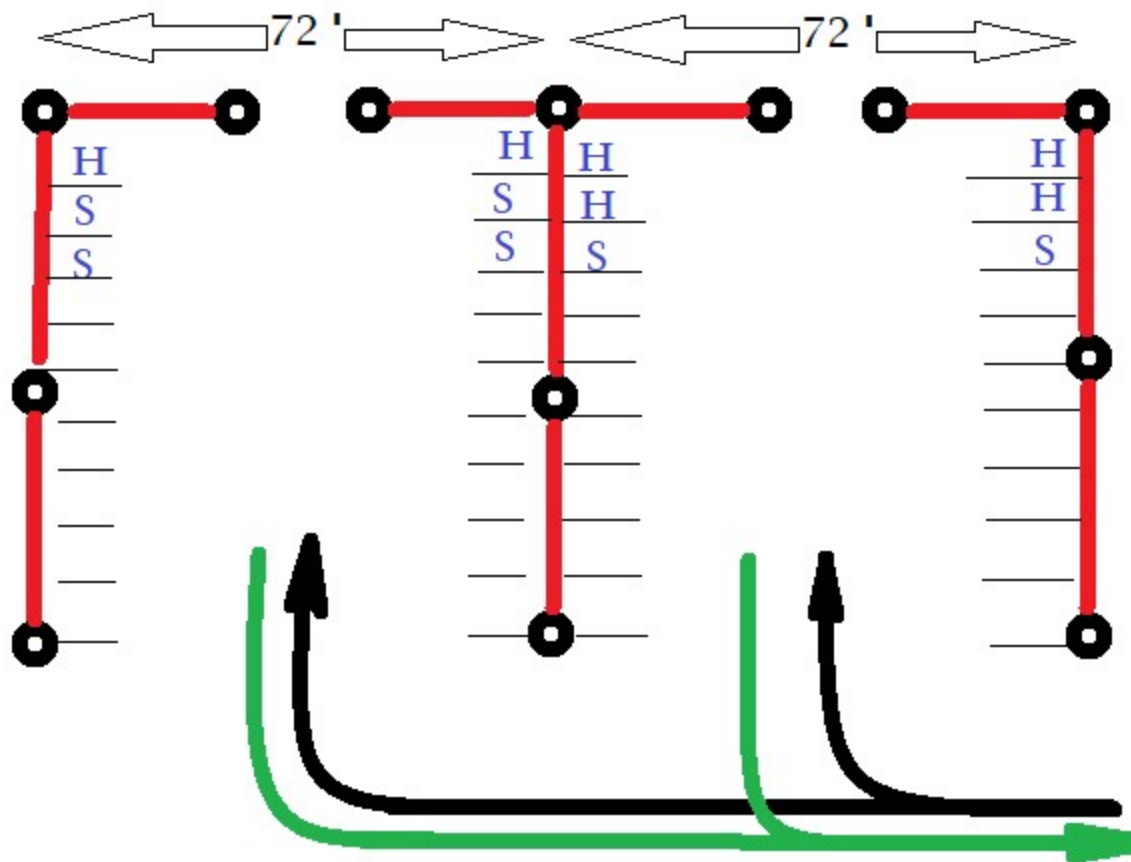
The 23 trees must be placed inside of the 15 foot buffer.
